**Consultation Response from KC,  
Policy**

**2023/91704 Almondbury Cricket Club, Fernside Avenue, Almondbury, Huddersfield**

**Prior notification for proposed 20m high Valmont climbable monopole on 5.2 x 5.2 x 1.4m deep concrete base with config 2 circular headframe for 6 antenna apertures at 60°/150°/320° and 4 600 dishes; MHA's and active routers to be fixed to headframe behind antennas and associated ancillary works**

**Date Responded:21/06/2023**

Title: **003 ACCESS PLAN**

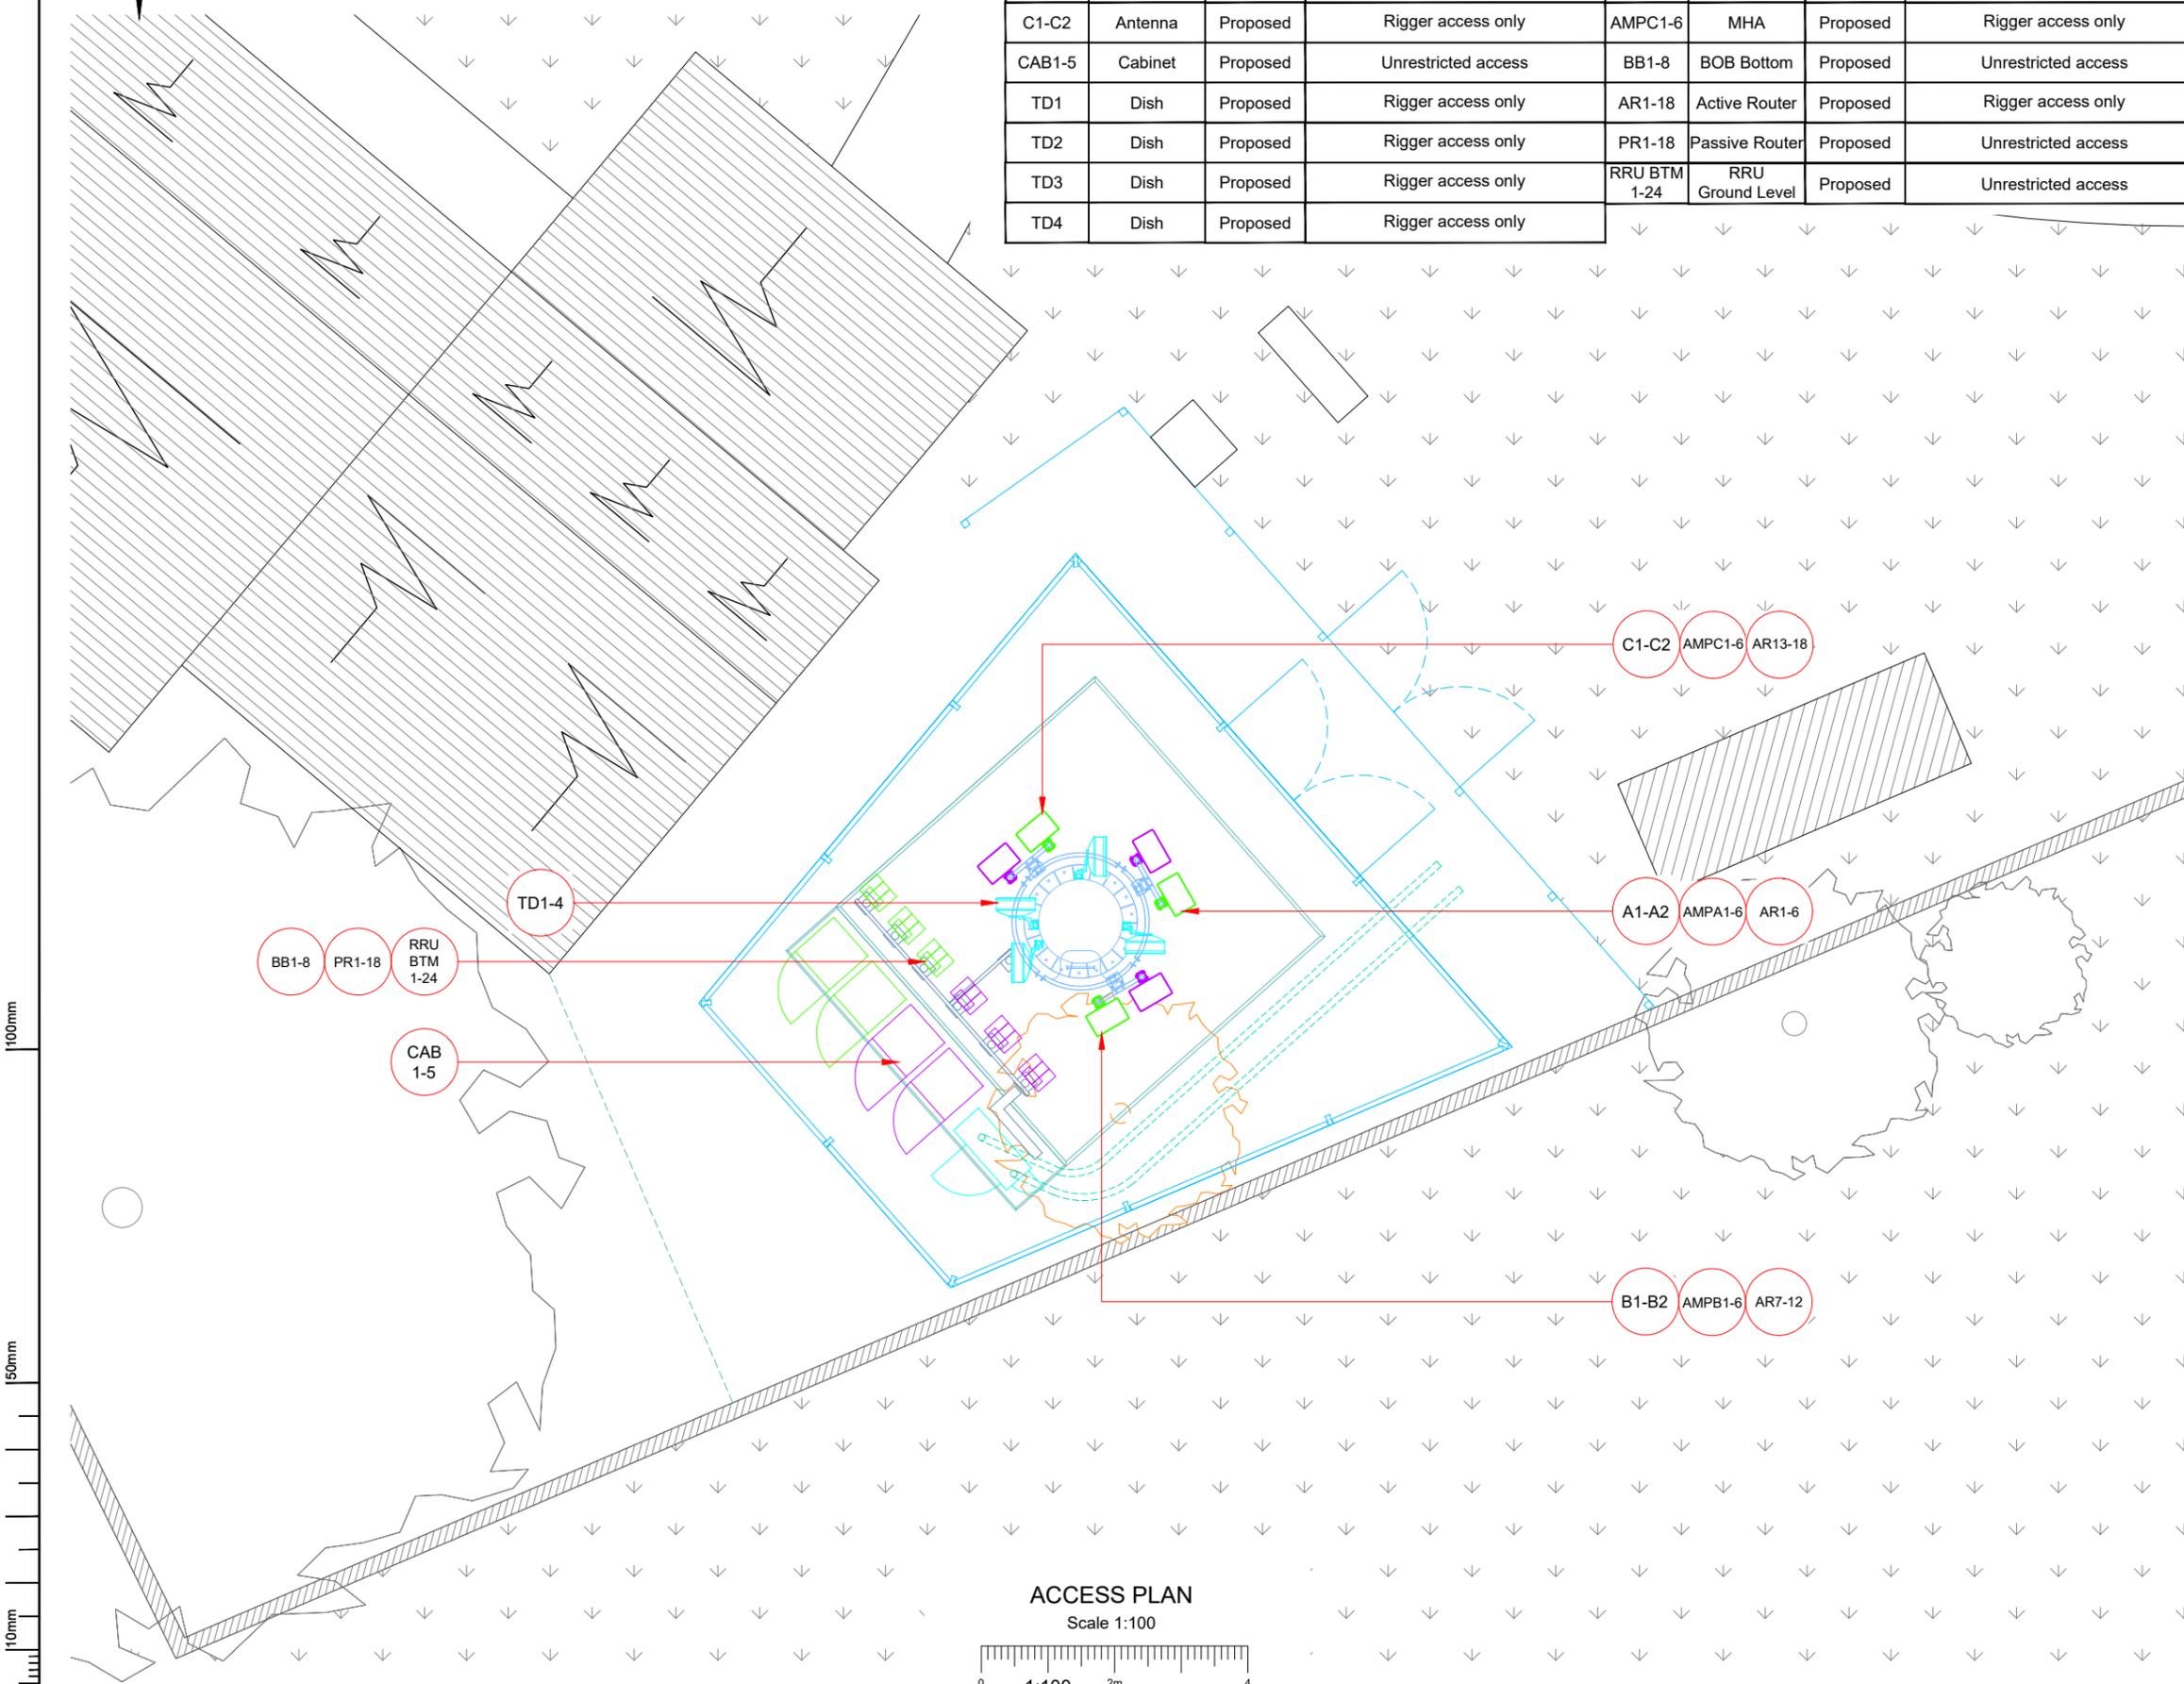
Whilst this is a prior notification, consideration of the proposed development against Local Plan policy LP61 (Urban Green Space) should be given to any loss of UGS, which will need to be determined by your site visit.

If there is a loss of UGS this would not be consistent with LP61 in that the UGS site, in active use as a cricket ground, is required to meet local sporting needs and has not been identified as clearly no longer required. The proposal is not providing replacement open space provision as set out in criterion (b) of LP61, and is not for an alternative open space, sport or recreation use as set out in criterion (c) of LP61.

As this proposal is located within an existing cricket ground Sport England should be consulted for their comments regarding any potential impact on the use of the playing field as a cricket pitch and ball strike issues.
